INTAKE SCREENING COMMENT RESPONSE LETTER

8541 SE 82ND ST / Permit # 2406-148

**SITE PLAN - EXISTING**

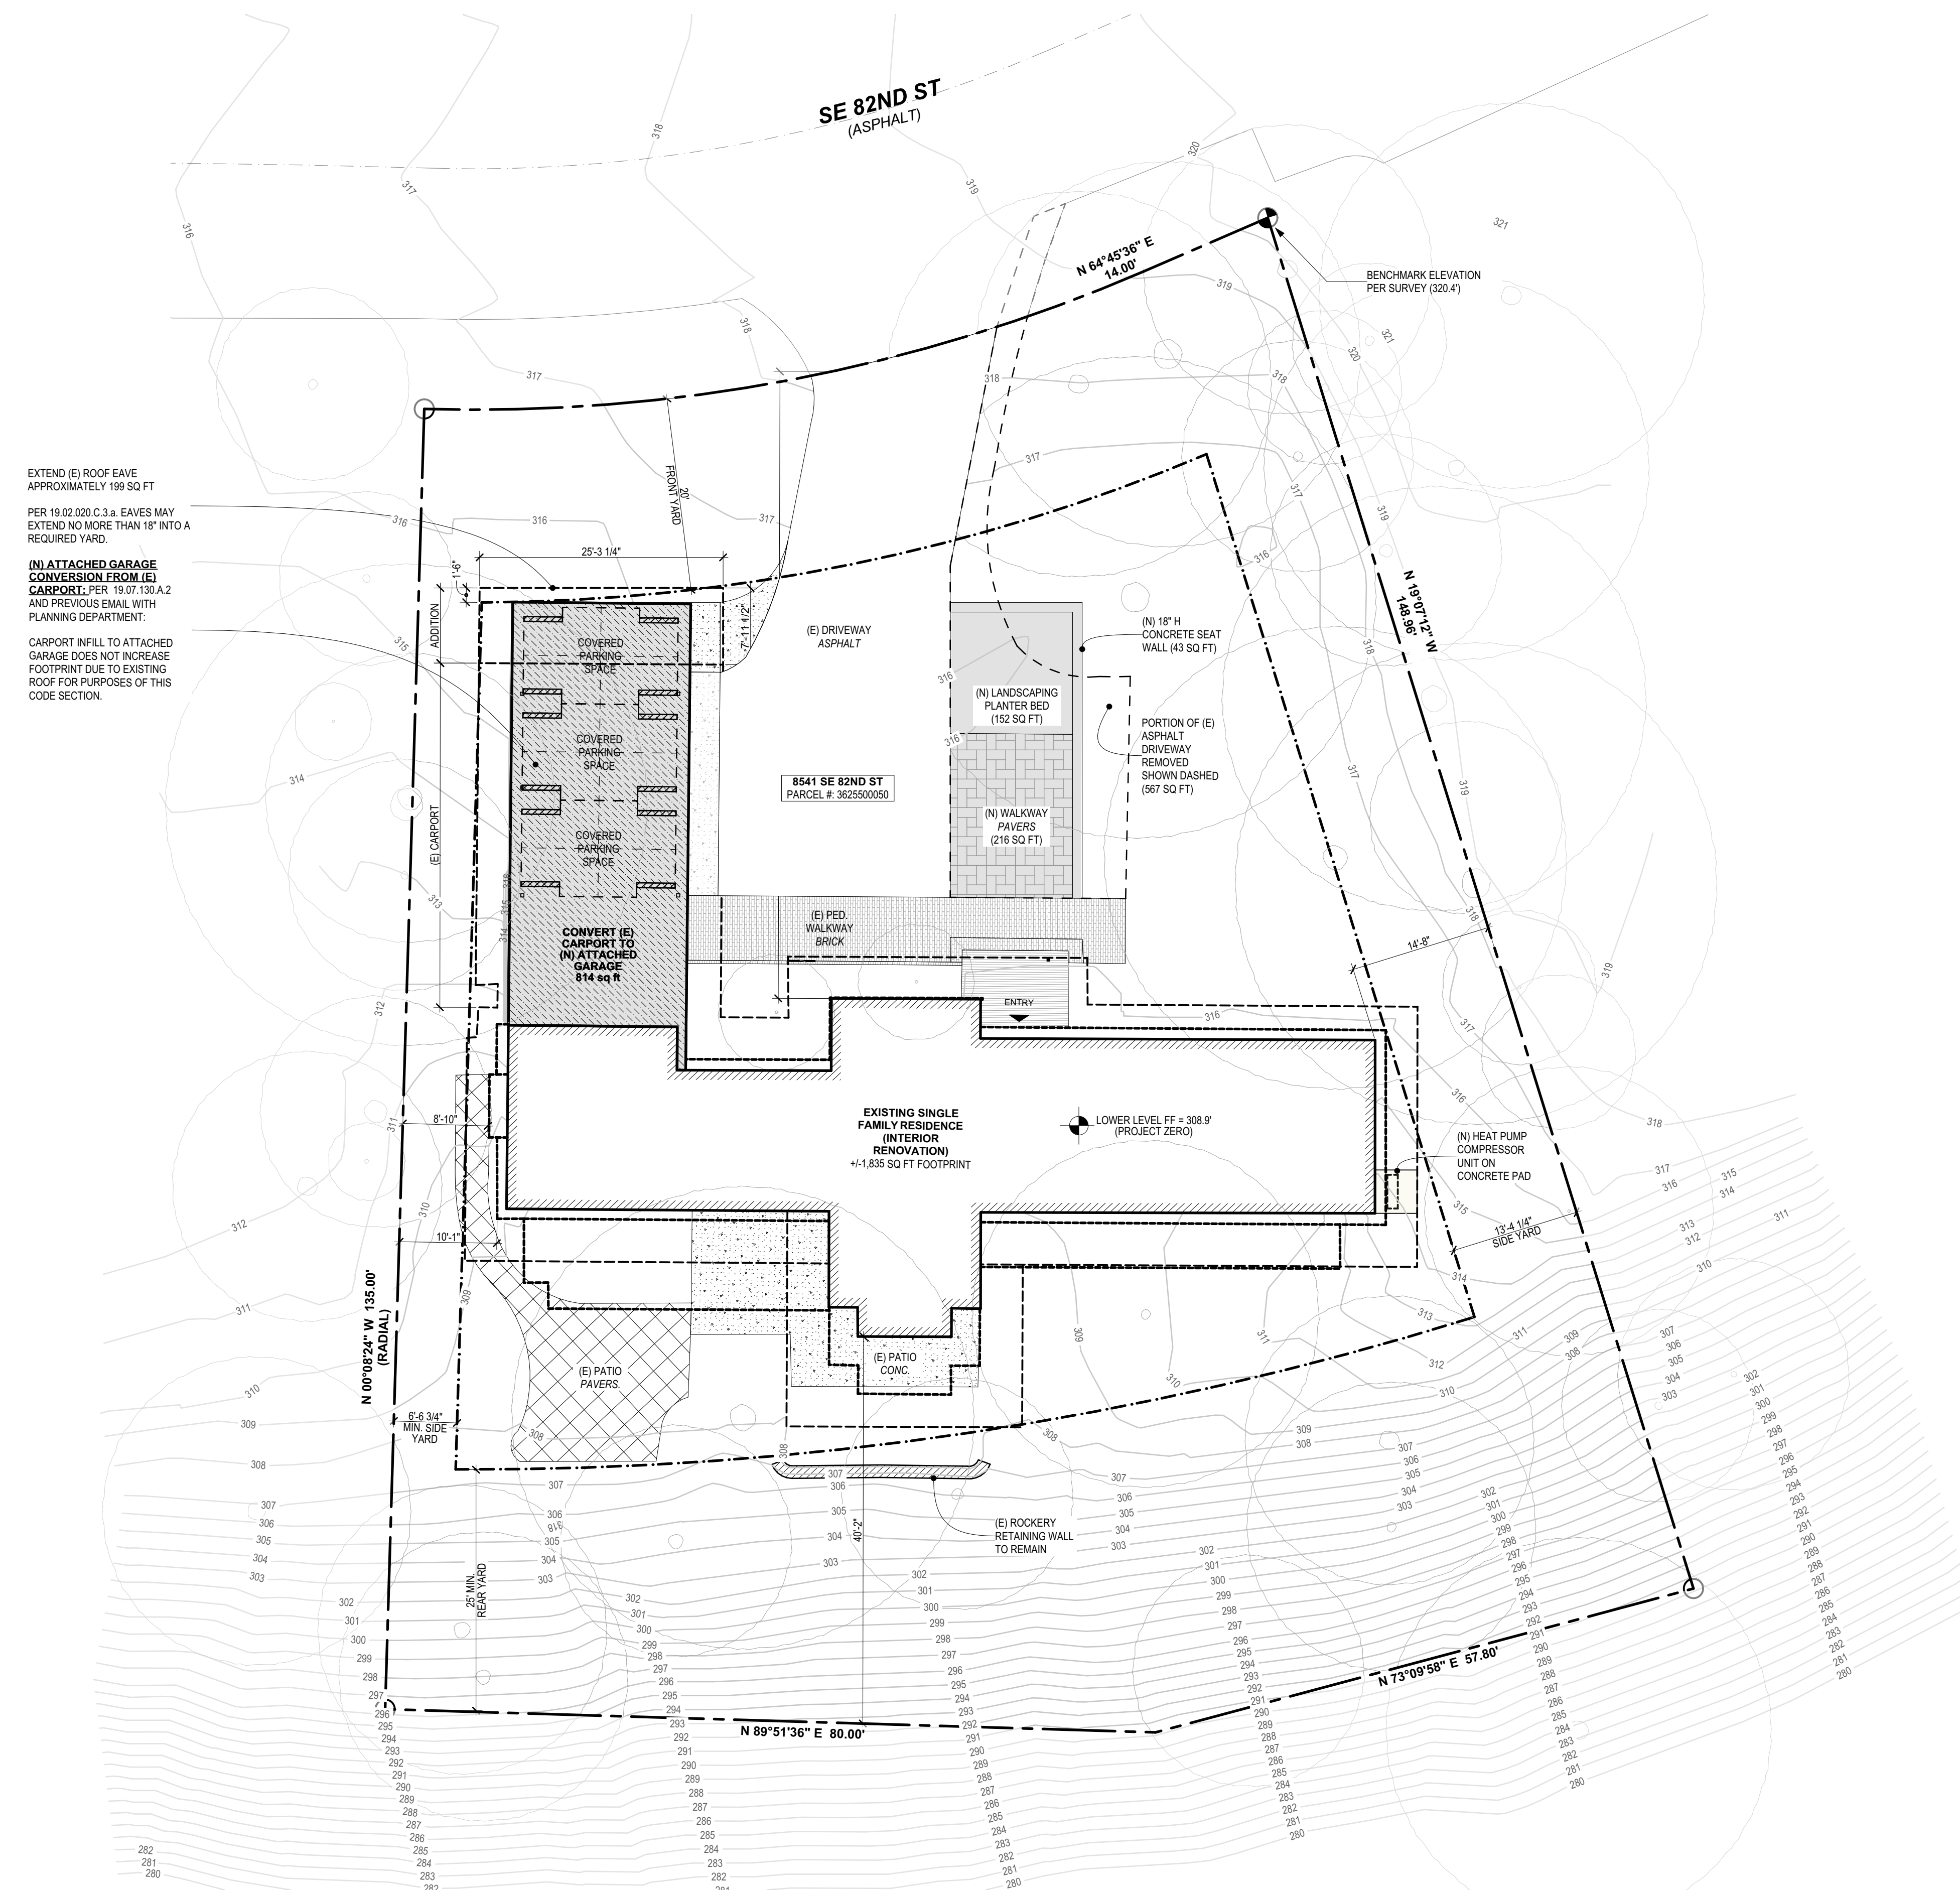
The subject property contains several geologically hazardous areas. Per MICC 19.07.090, a Critical Area Review 1 (CAR1) is required if the proposed development either is demonstrated to not be located within geologically hazardous areas OR that the proposed development meets all of the criteria in MICC 19.07.130, Modifications. Provide documentation that the proposed development meets one of these criteria. If it cannot be demonstrated that the proposed development meets the

criteria for a modification, then a Critical Area Review 2 (CAR2) is required under a separate permit application.

Documentation and required submission materials are included with the resubmitted permit package showing that the proposed development meets the criteria for Critical Area Review Type 1 under MICC 19.07.130, Modifications.
